FULL

Reference:	H11-0726-22	Date of Decision:	19th October 2022
Applicant:	Mr K Bunn Jecady Blazegate Long Sutton Spalding PE12 7HJ		
Location:	Churchills West Street Long Sutton Spalding		
Description:	Conversion of snooker room into 2 bedrooms to be rented out to general public (no breakfast will be provided)

South Holland District Council hereby give notice that this application has been REFUSED for the above proposal for the following reason(s):

SITE PLAN

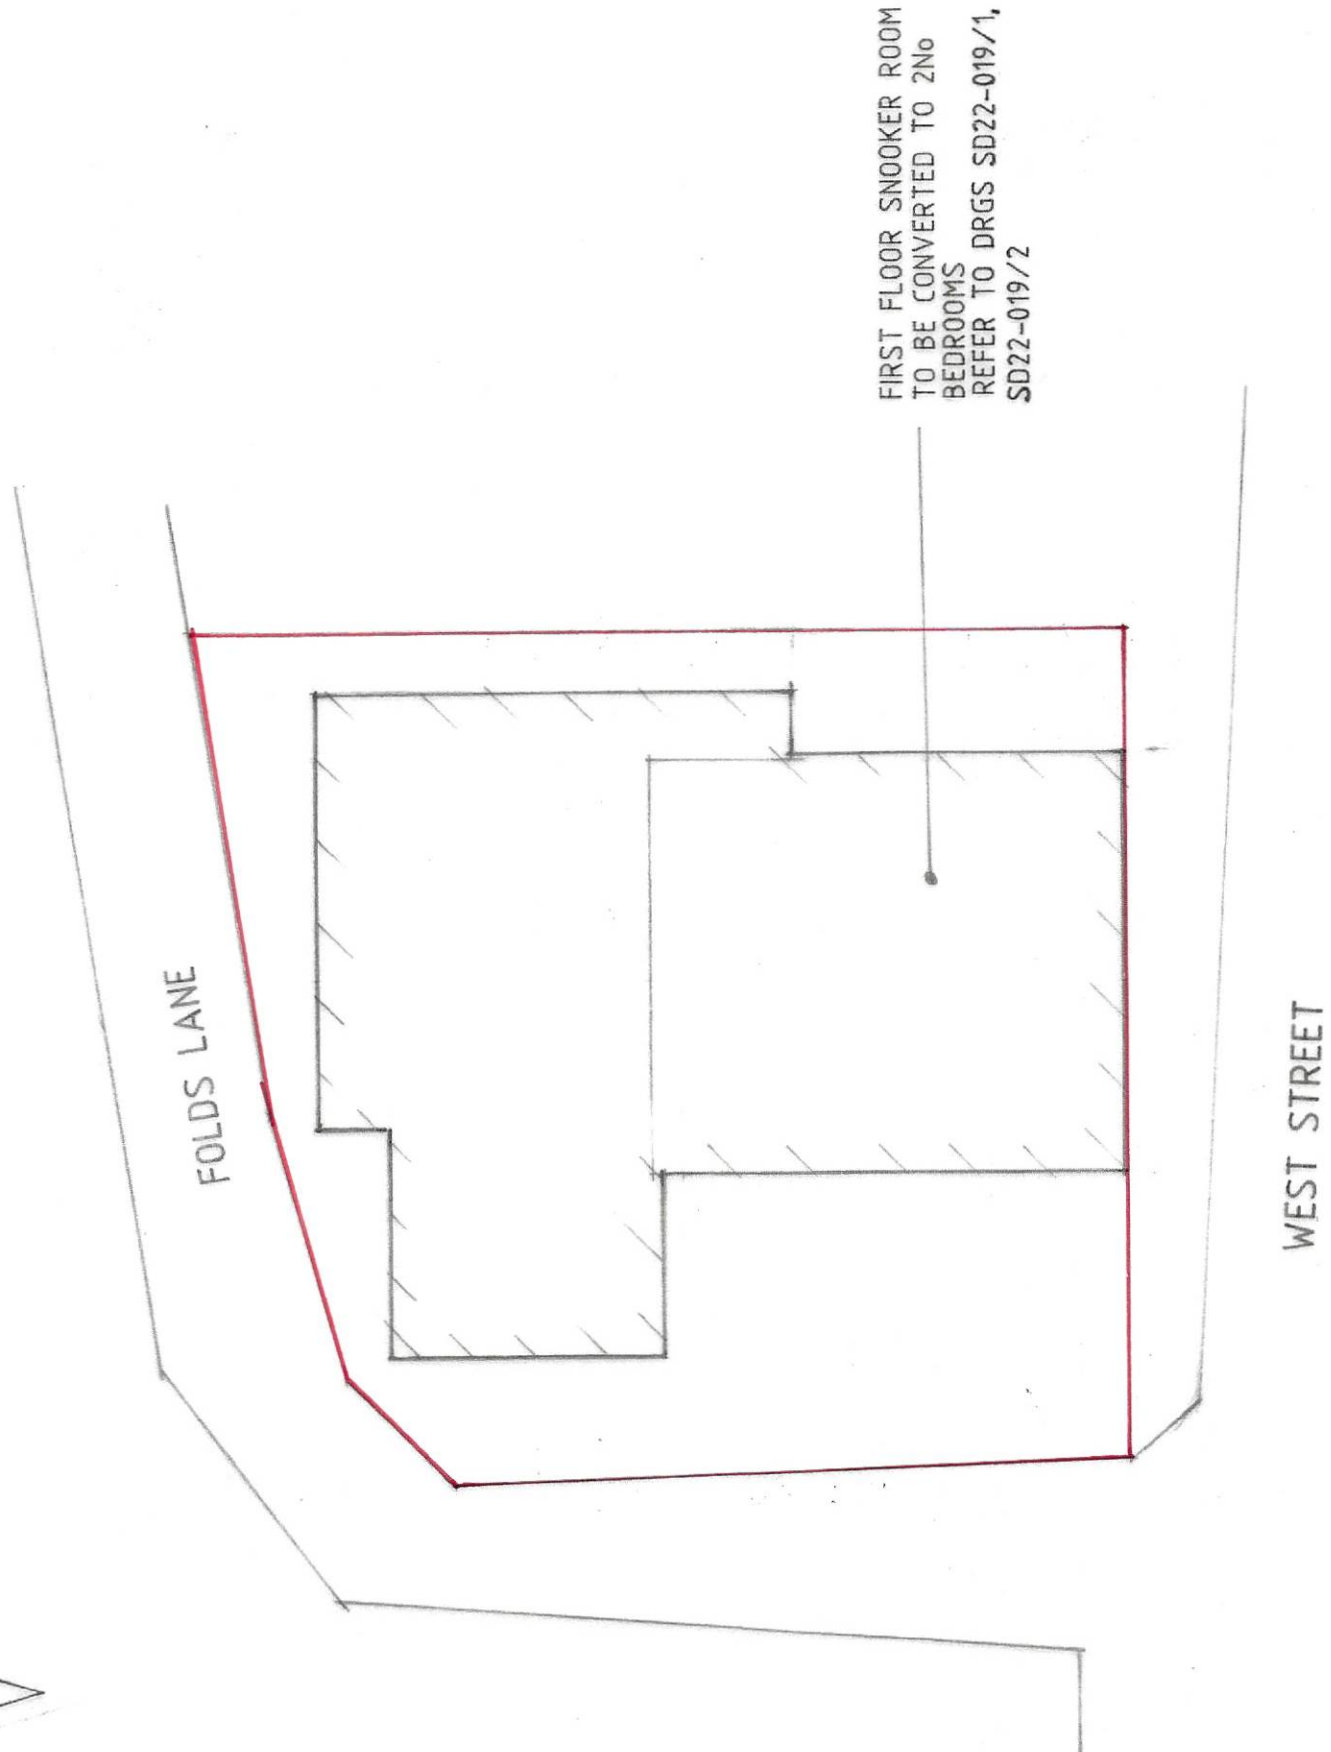
- 1 The proposal is contrary to Policies 2, 3 and 36 of the South East Lincolnshire Local Plan (2019) as well as the provisions of Appendix 6. Appendix 6 (linked to Policy 36) sets out the minimum requirements for car parking provision. 2 car parking spaces are required within the site (1 for each guest bedroom). However, the site does not have any provision for off-street parking therefore the development would not meet the current parking standards. As such it would result in highway safety issues and a cluttered street appearance due to additional vehicles being parked on the road, also contrary to the aforementioned policies.
